REVISION RESPONSE LETTER

**RE: BC Smith Inc. DBA Crackerjack Mud Jacking
Site Development Plan
File Number PPR-17-031**

DATE: August 23, 2017

1 SITE PLAN  
SCALE: 1"=20'-0"

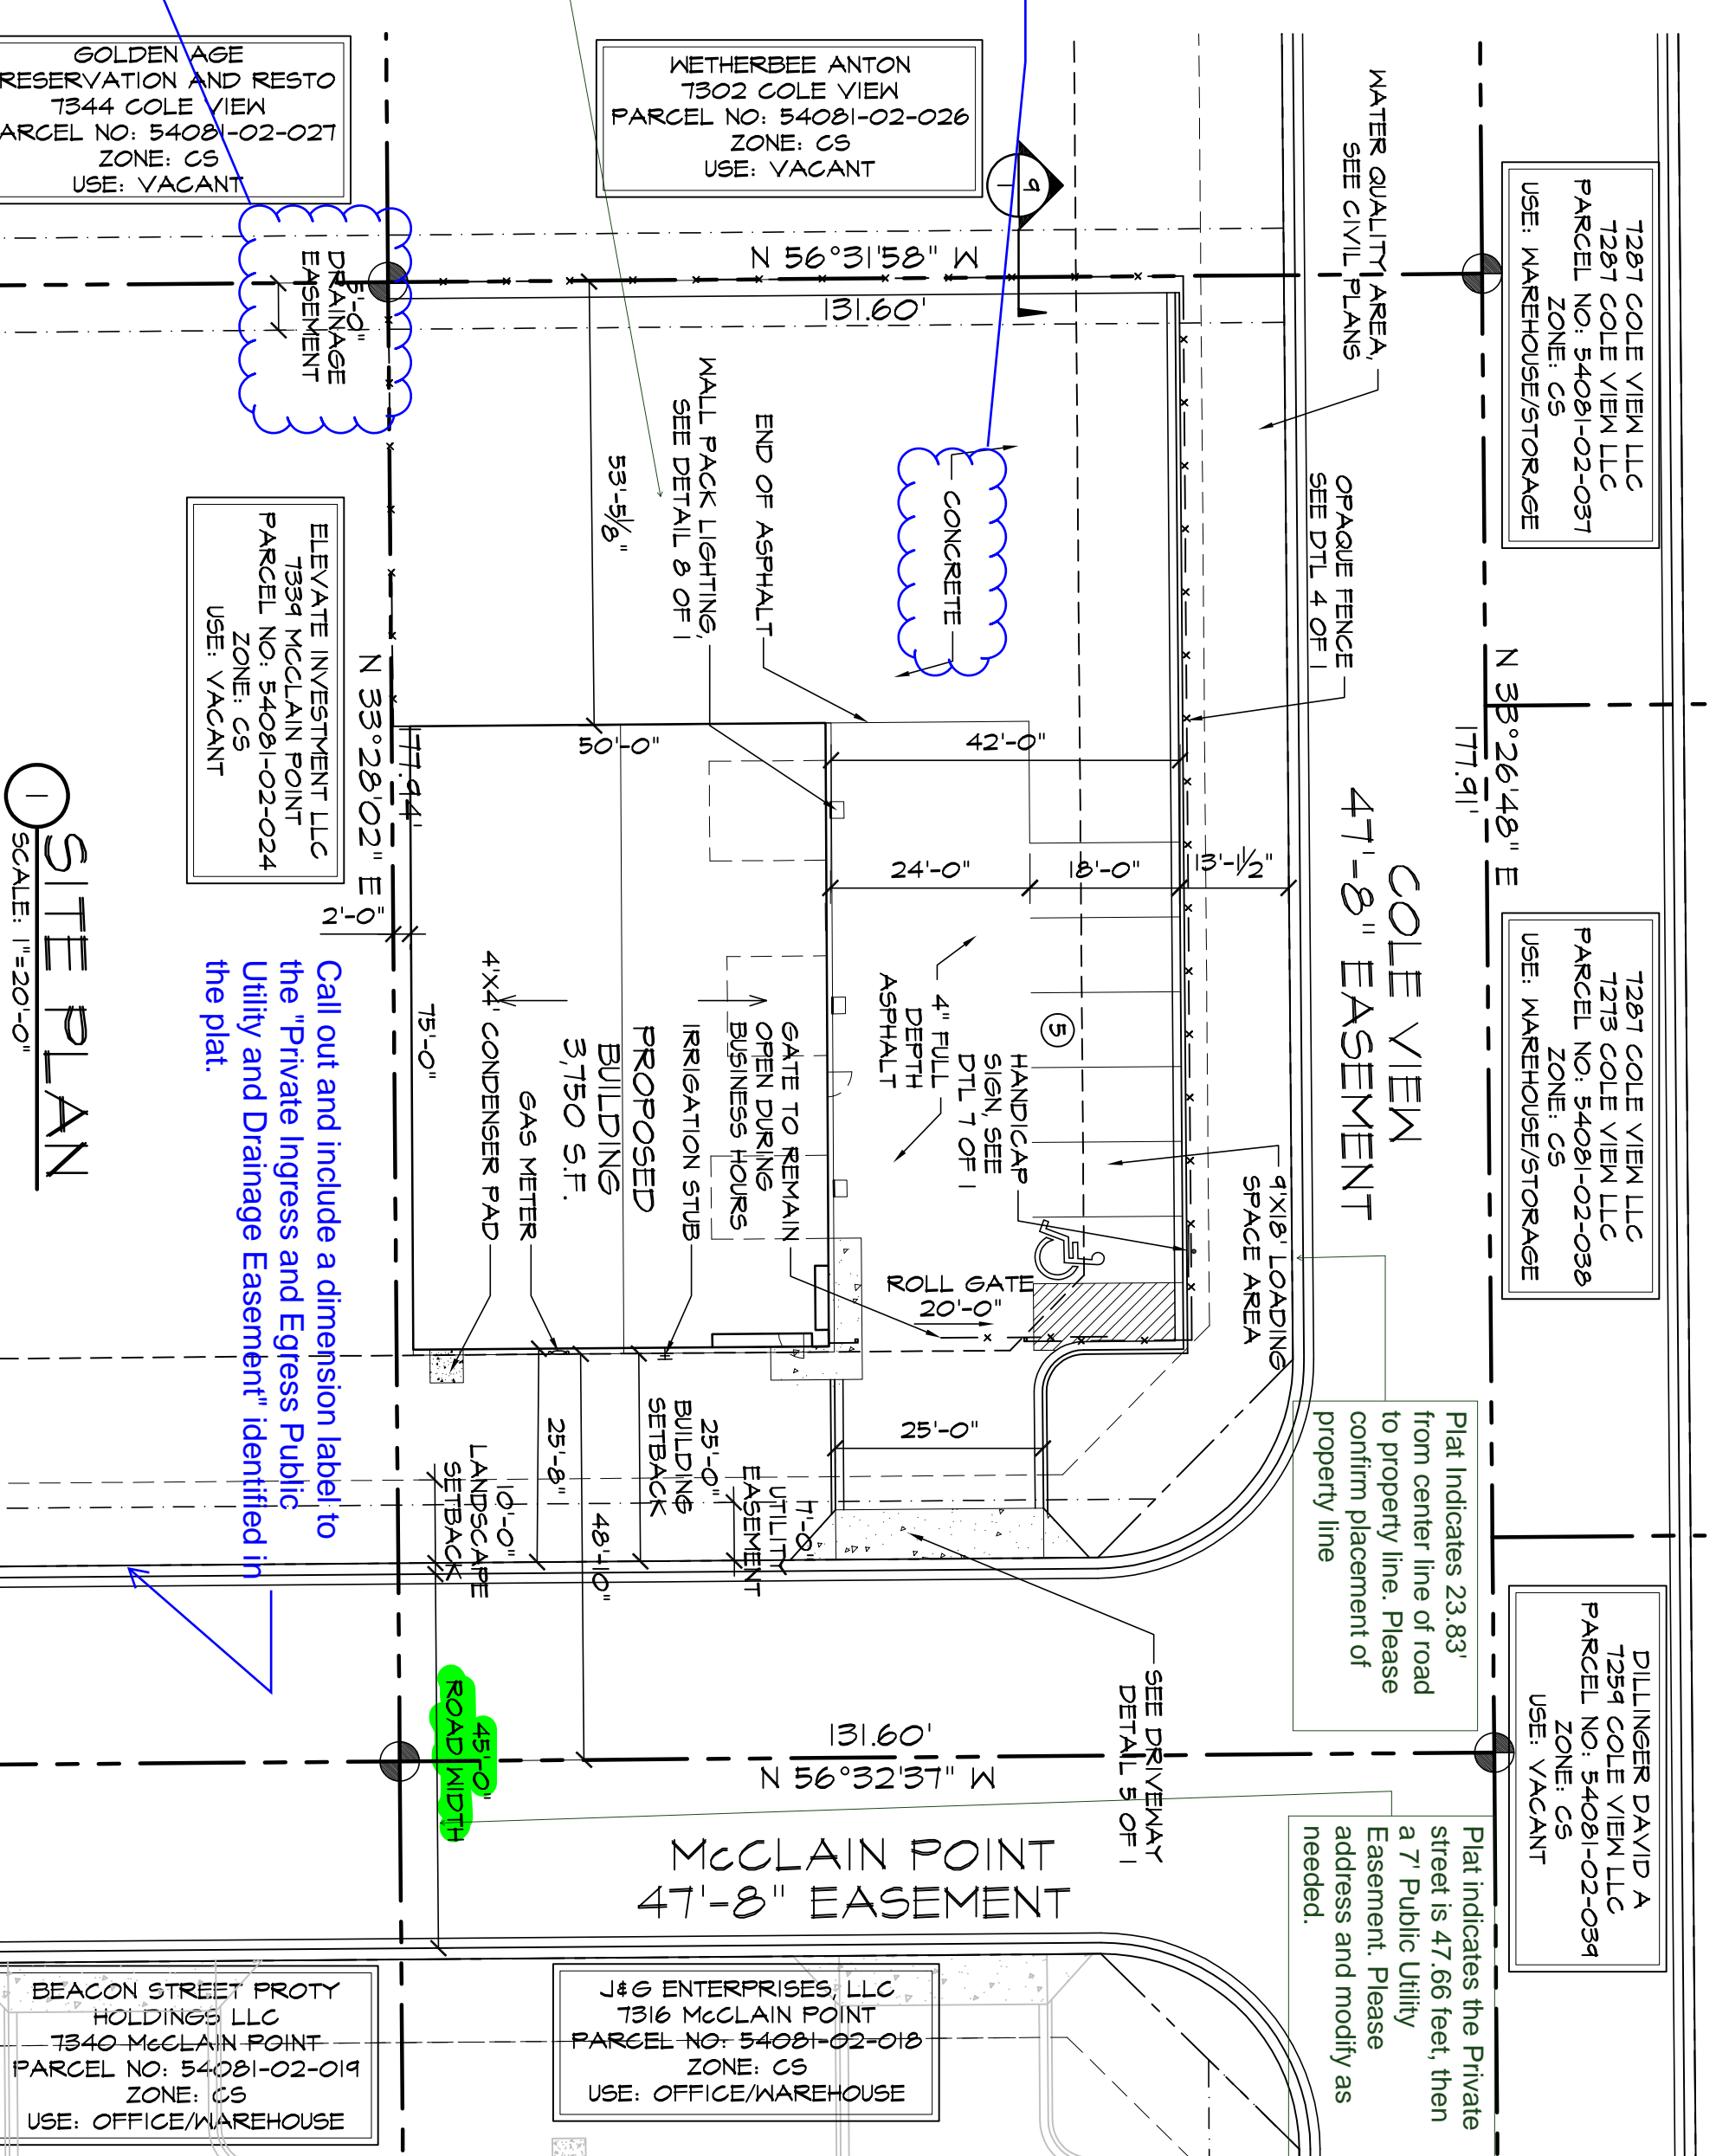
1. *See Redlines for comments*
Redlines Updated, Raingarden added as per Civil Plans.
2. *Applicant is required to apply for a Building Permit with PPRBD* **Noted.**
3. *Applicant is required to apply for a Driveway Permit* **Noted.**
4. *Schedule a pre-construction meeting with Inspections* **Noted.**
5. *Landscaping must be installed prior to Certificate of Occupancy.* **Noted.**

GRADING PLAN

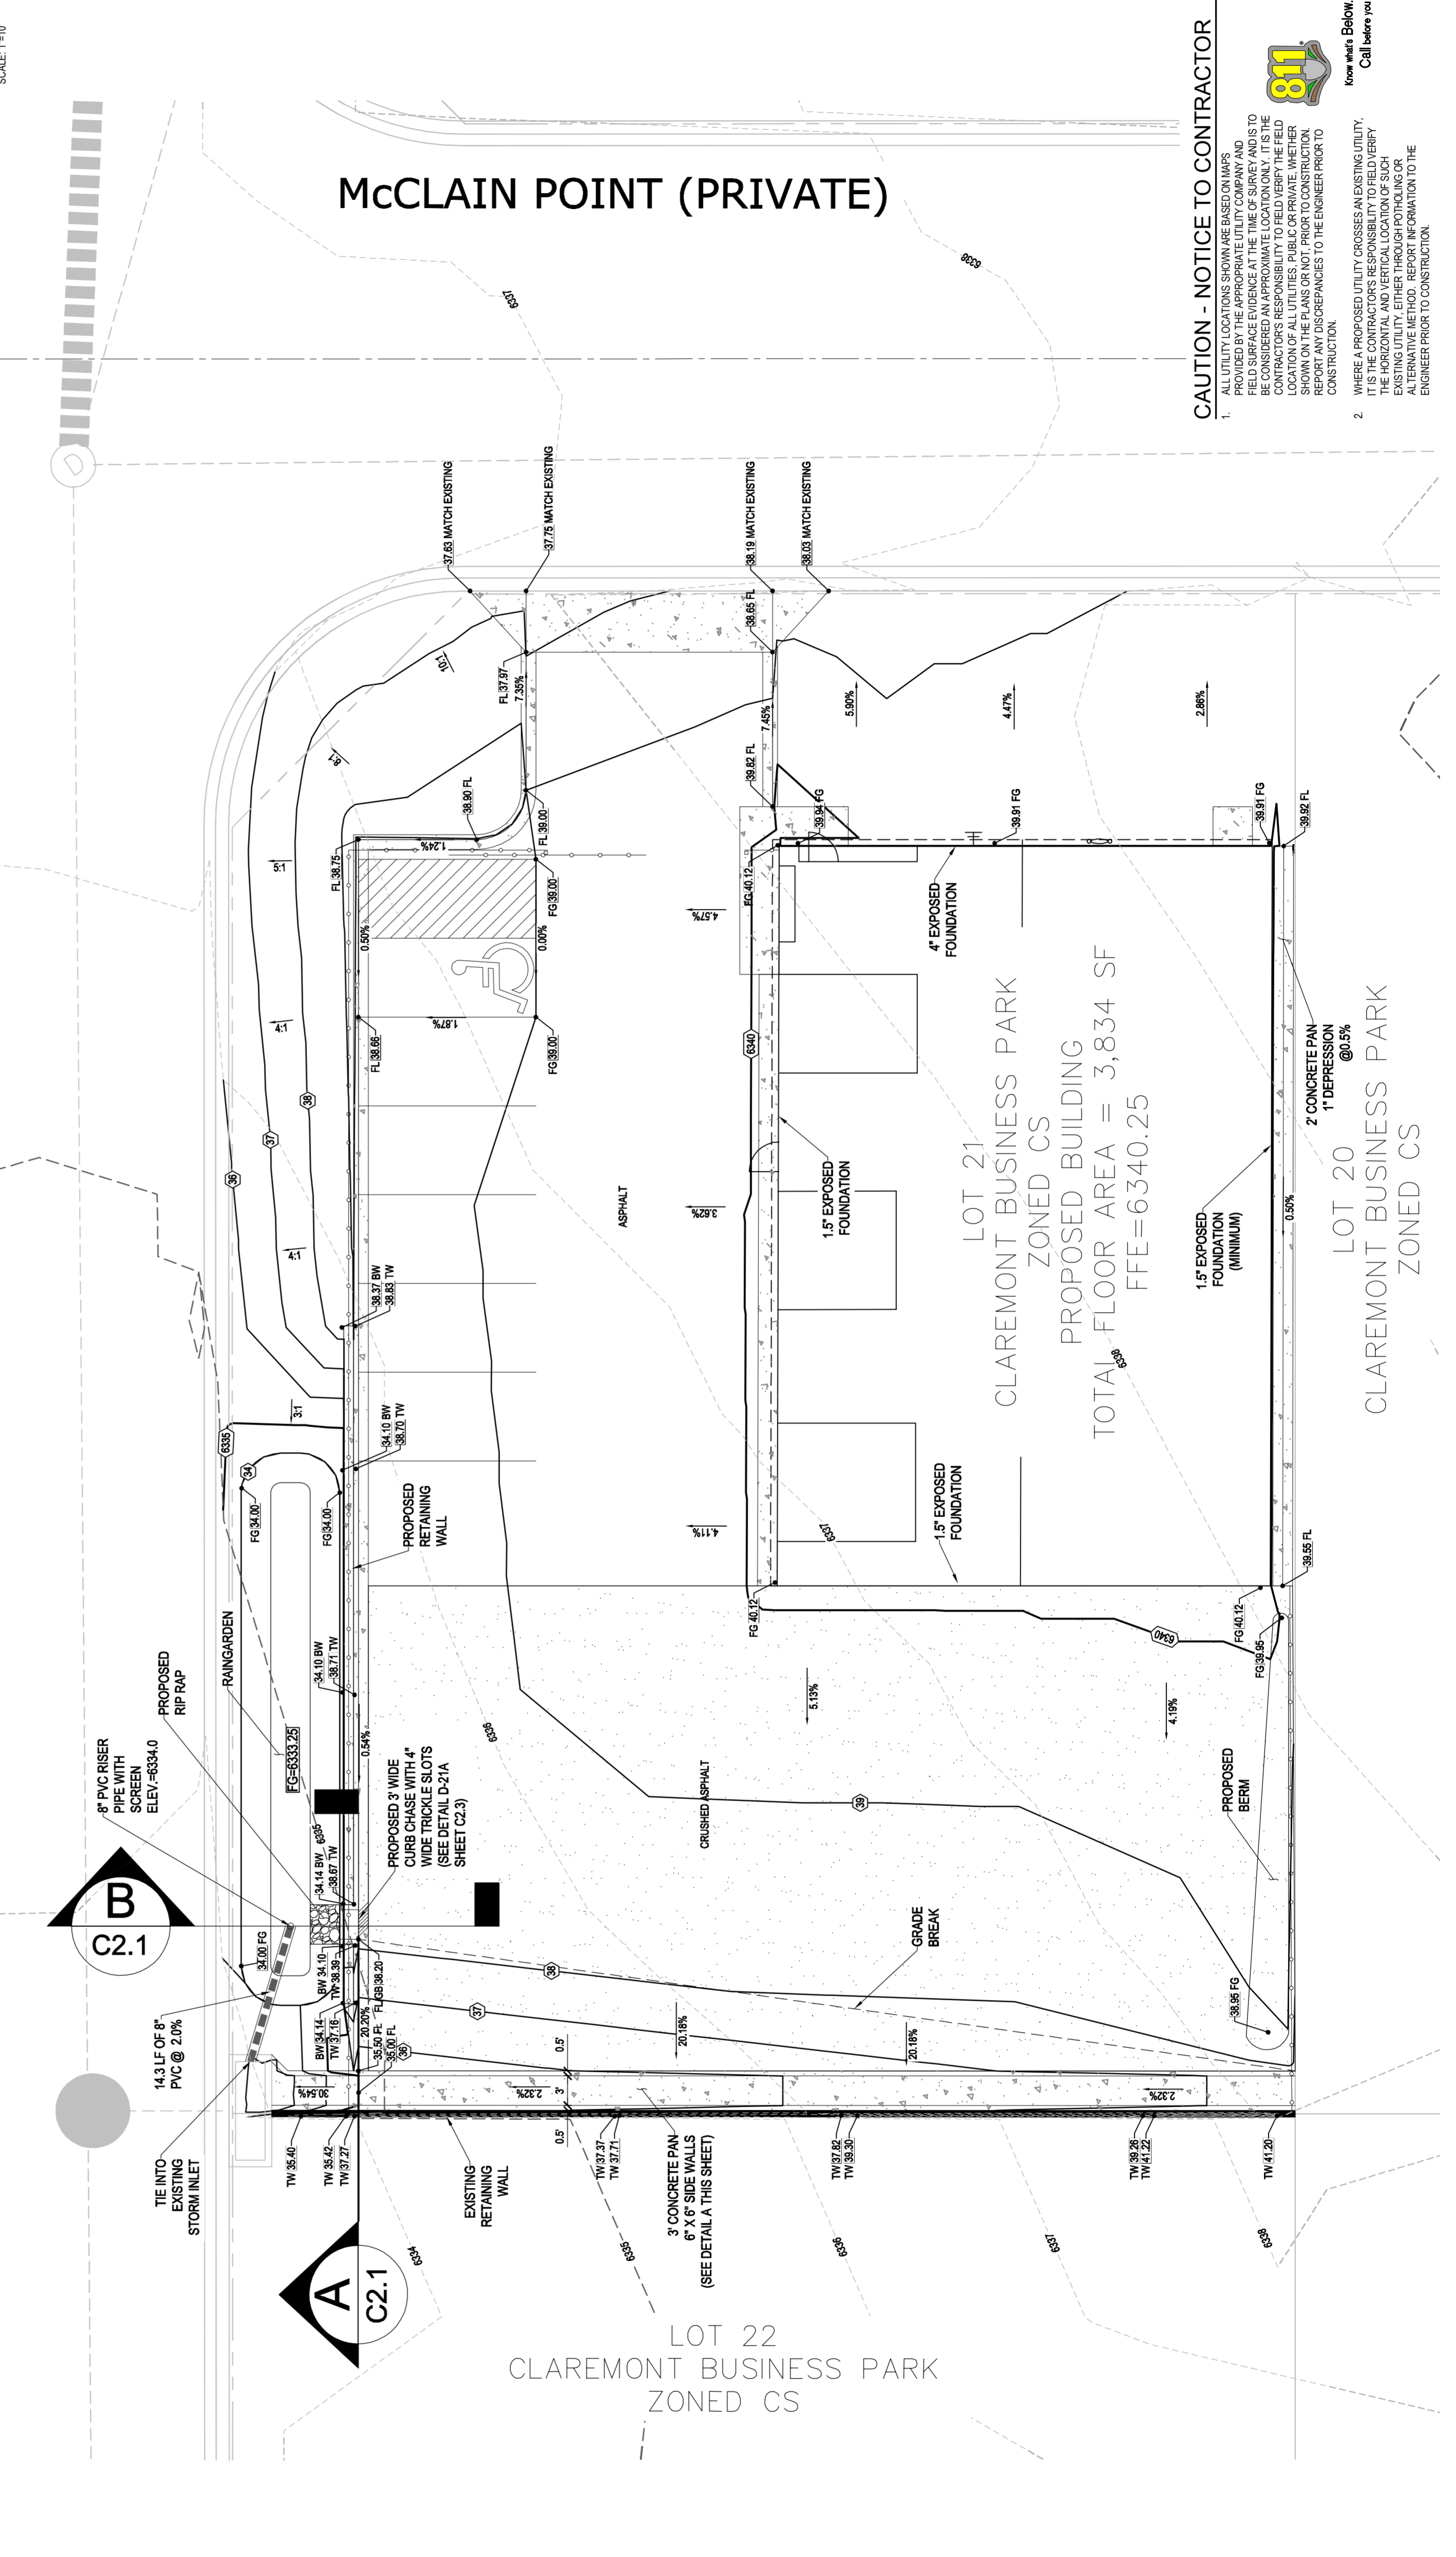
Show and label the drainage easement along the lot line.

Show the actual retaining wall cross section which includes the footers.

Since the retaining wall is greater than 4 feet in height building permit is required.

Therefore, add a callout stating a building permit is required for the retaining wall.

Revise linework so the ground slopes towards the pond.

Identify the riprap LxWxD and D50 Size.

Show and label both the WQCV and 100yr water elevation.

Callout the lowest top of curb elevation fronting the rain garden.

Per the CBP Fil 2 FDR, Q5 & Q100 will be directed to the private 10' Type R inlet which has the throat opening facing into the property.

Current design and the narrative of the drainage letter indicates runoff over-tops onto Cole View instead of being directed into the inlet. Runoff from a 100yr storm must drain into the inlet, not the street.

Label to lot lines and easements.
Include the bearing/distance for the lot lines.

Identify the side slopes for the berm.

Based on the grading, this area is not routed into the rain garden. Update the design so this area is treated by a WQ BMP.
